From: Kerry Simmons [REDACTED]
Sent: 25 June 2020 14:33
To: Simon Davis <Simon.Davis@arun.gov.uk>
Subject: AL/27/20/PL - Hook Lane, Aldingbourne

Thank you for forwarding Mark Warwick's response to our additional information and clarification in relation to impact on trees. We are disappointed with Mark's assessment of the scheme's potential impact on trees when we have gone to great lengths to address the objections previously raised. We understand that Mark is solely interested in the retention and protection of individual trees as well as the site's amenity value and we believe we have demonstrated that the current layout has overcome the 'in principle' objection regarding the previous application. We therefore find Mark's continued objection and resistance to be unreasonable and driven by ideals, rather than a balanced understanding of the moderate quality of the trees and the benefits of providing 9 additional new homes. The fact of the matter is that the application provides technical evidence from Lizard Landscape that the trees worthy of retention can be adequately protected in line with the required British Standards, indeed Mark doesn't actually dispute this, he is simply

Proposed Block Plan 1:500@A3

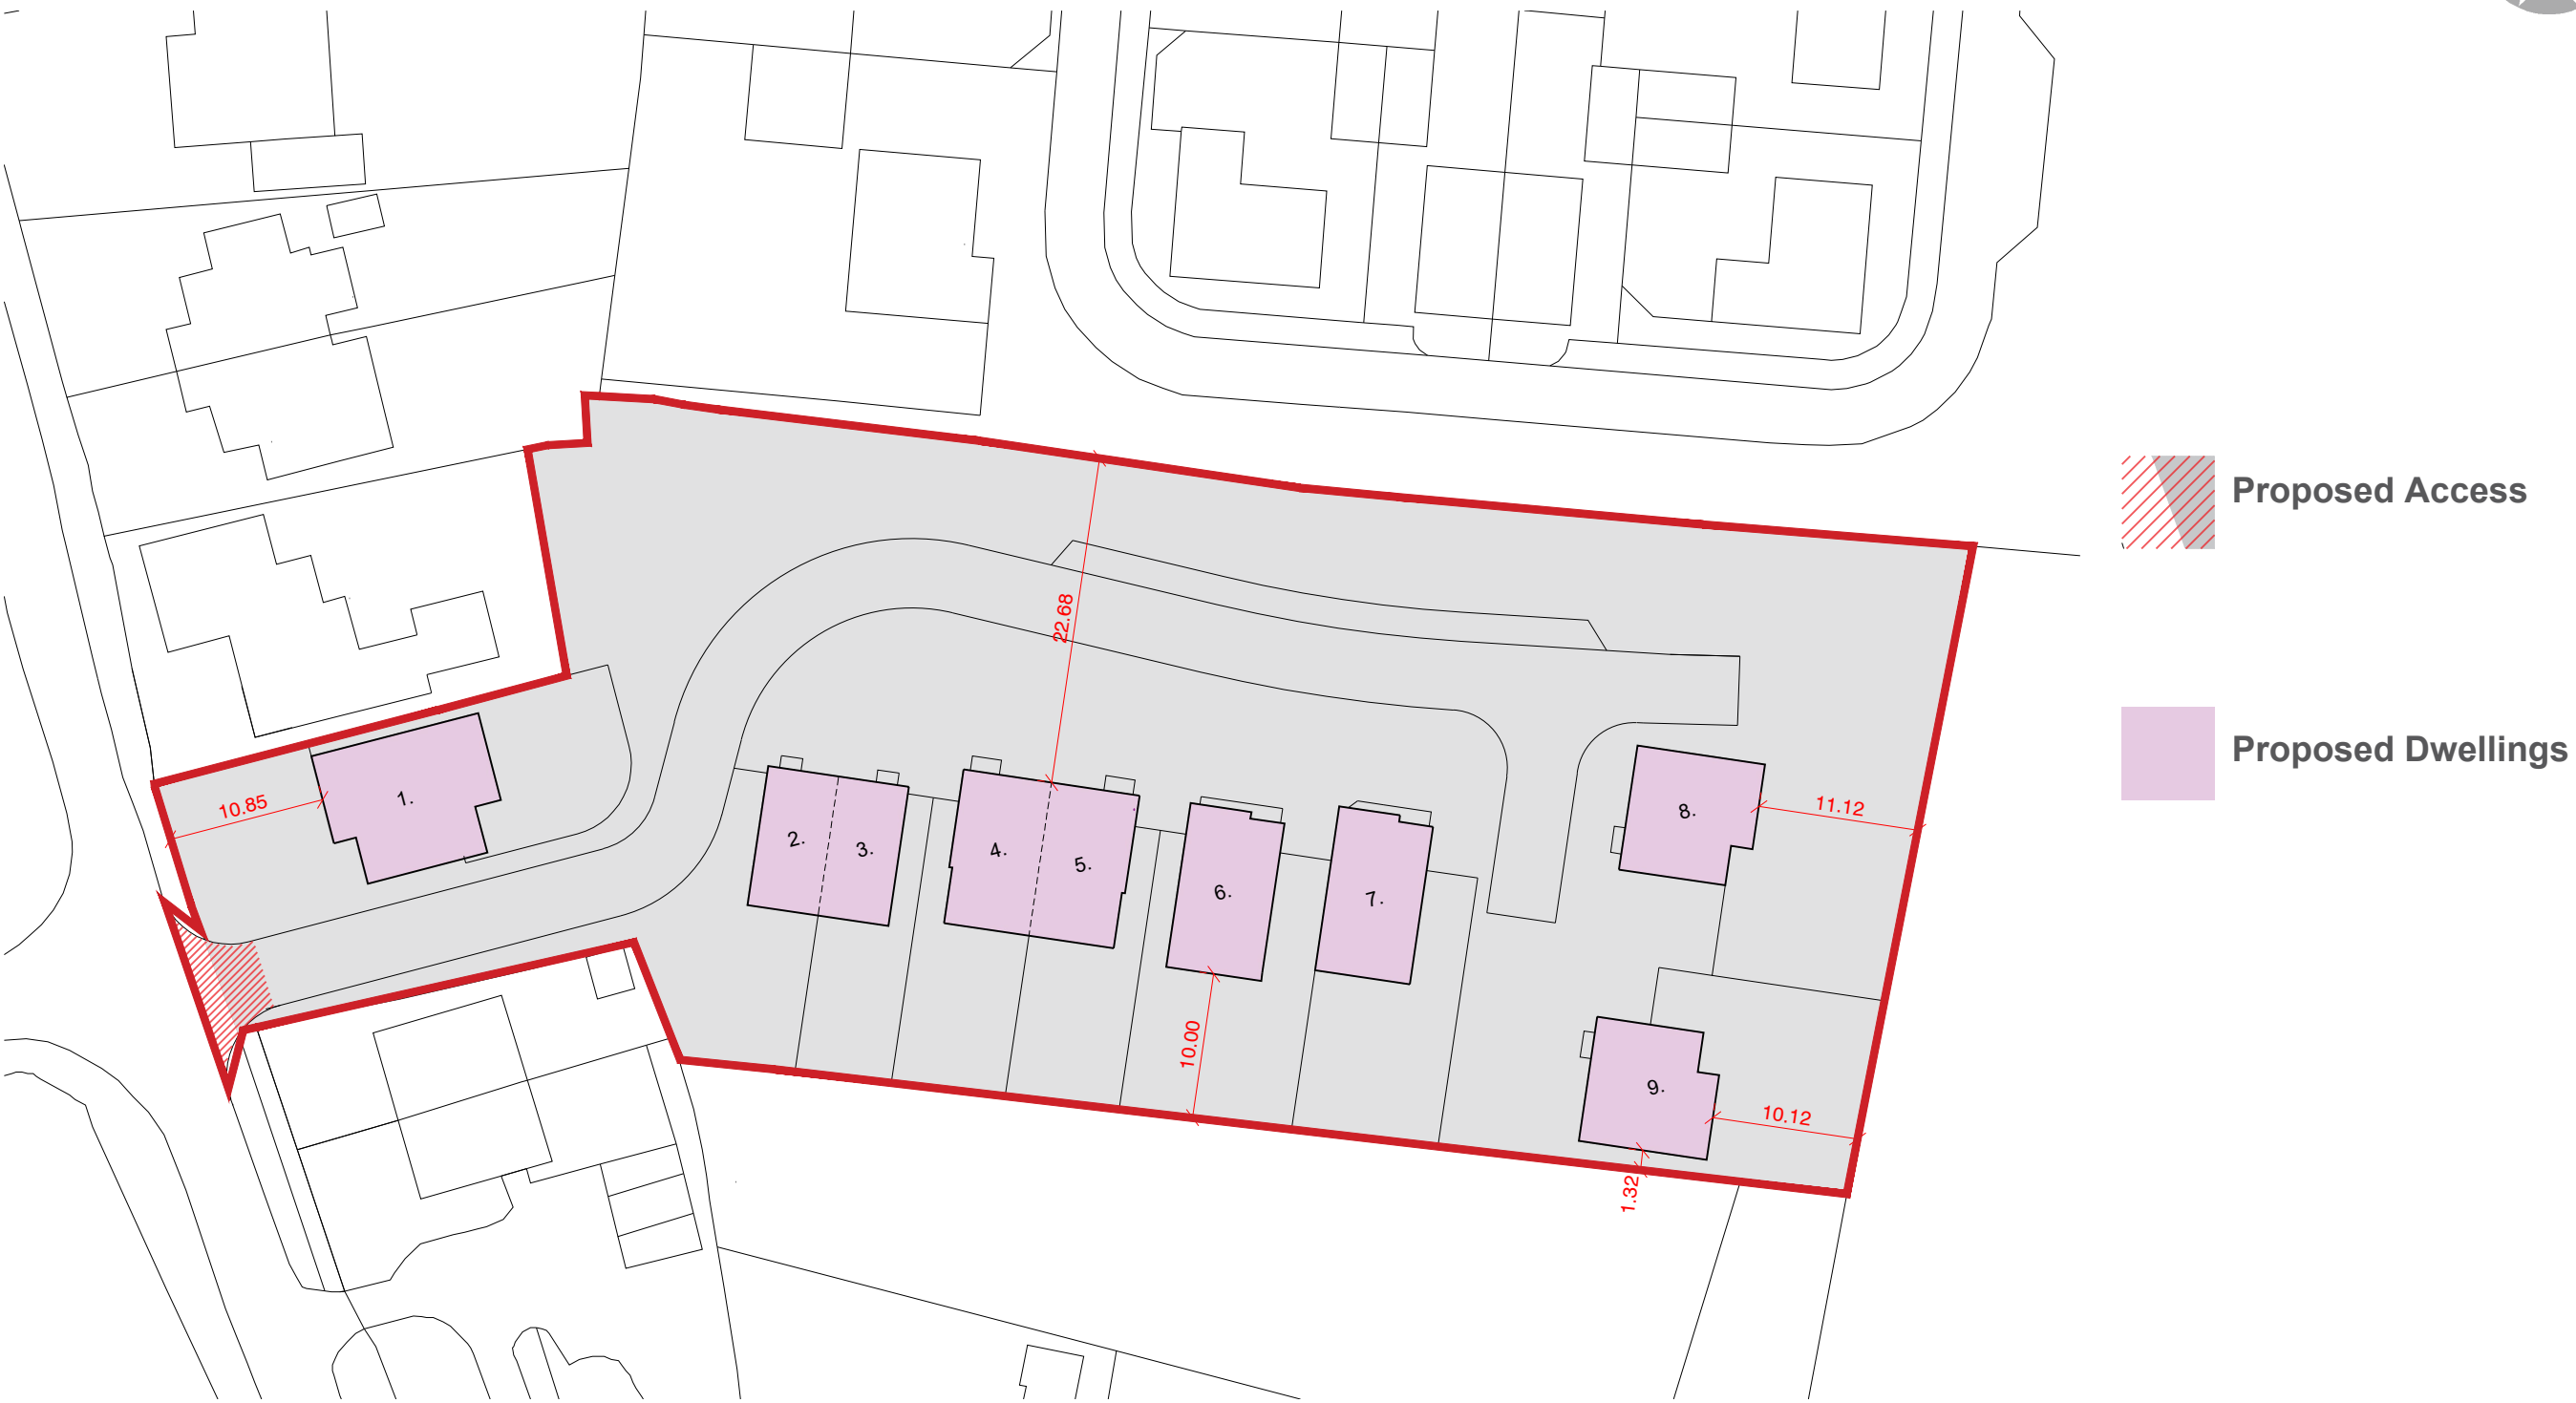
3. The TPO'd tree can be added to the drainage plan if considered necessary. However it is clearly not impacted by the proposals and its root protection zone will be protected as there is no requirement for an digging near or around it. Due to its position within the garden area of plot 8. The applicant would also accept a standard condition requiring fencing around the tree during construction to be in accordance with the current recommendations within the British Standard BS5837:2012 'Trees in relation to design, demolition and construction -Recommendations' as shown on the proposed tree protection plan, and if required, a site meeting with a representative from the Local Planning Authority to inspect and approve the protective fencing in writing.
